Lot 52
 Plan 2 reverse
 Parcel: 3414204006
 Elevation: Craftsman
 Crawl Space
 Master Plan#: M153729
 Model: M1002

PLOT PLAN

480 INDIAN GRASS ST. CALHAN, CO 80808
 MAYBERRY, COLORADO SPRINGS FILING NO. 1
 A PORTION OF SECTION 14 & 15, T 14S, R 63 W, 6TH PM
 COLORADO SPRINGS, EL PASO COUNTY, COLORADO

DISAPPROVED
 Plan Review

PLOT PLAN

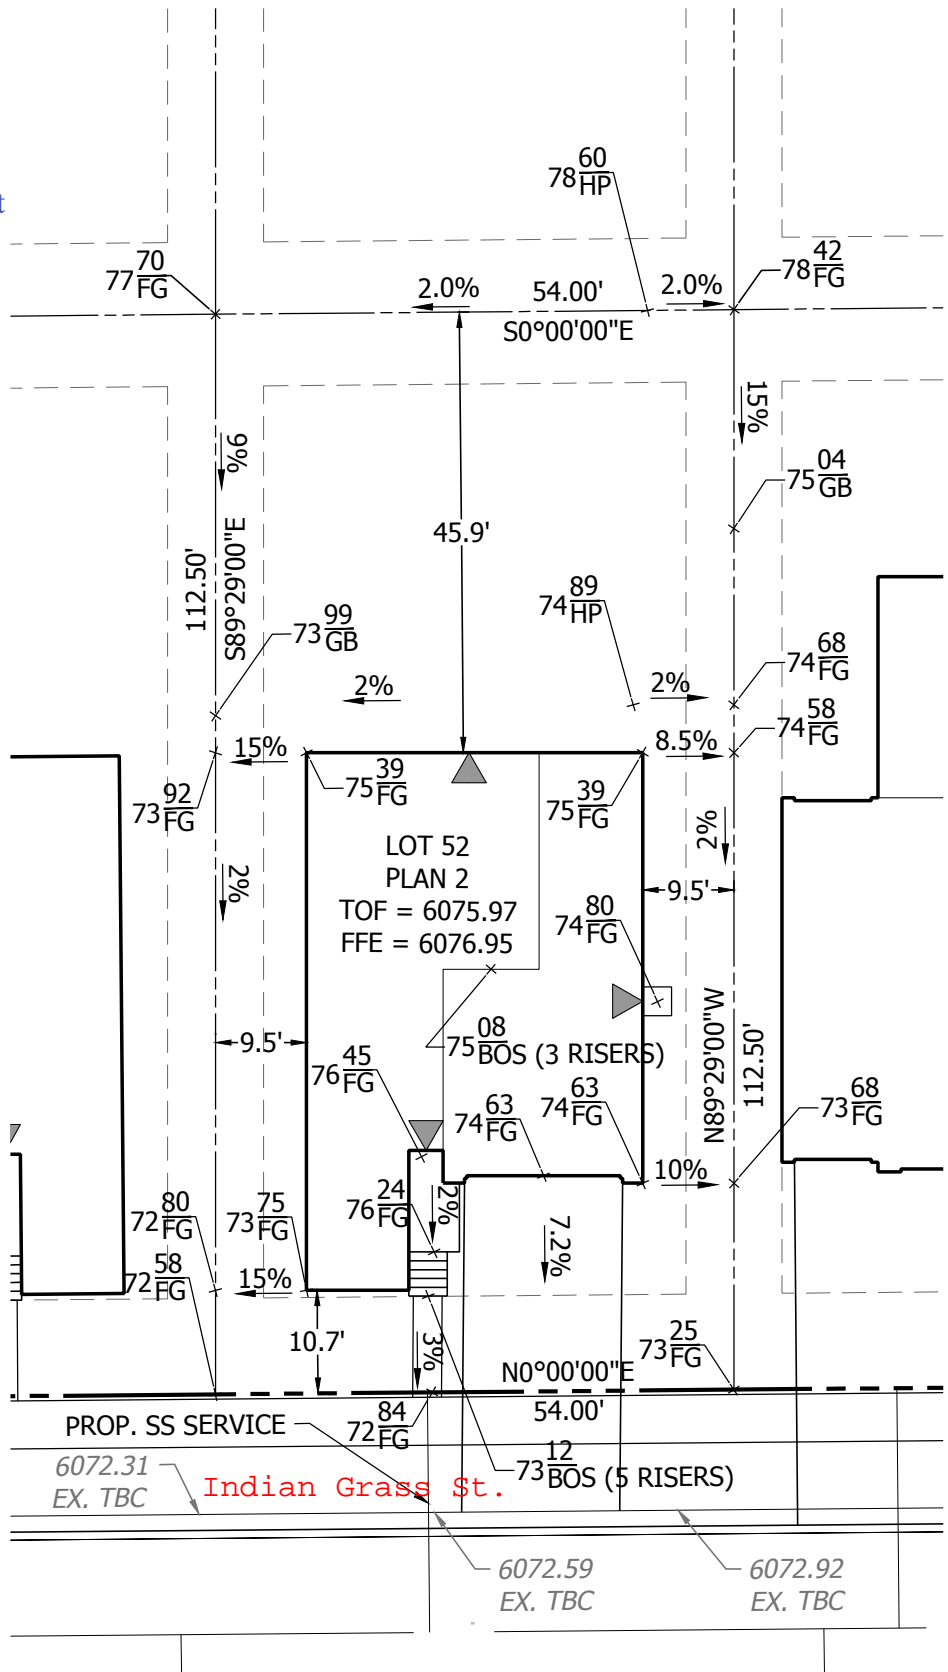
Provide site data (lot size,
 residence size, % lot
 coverage and average
 building height) on all site
 plans.
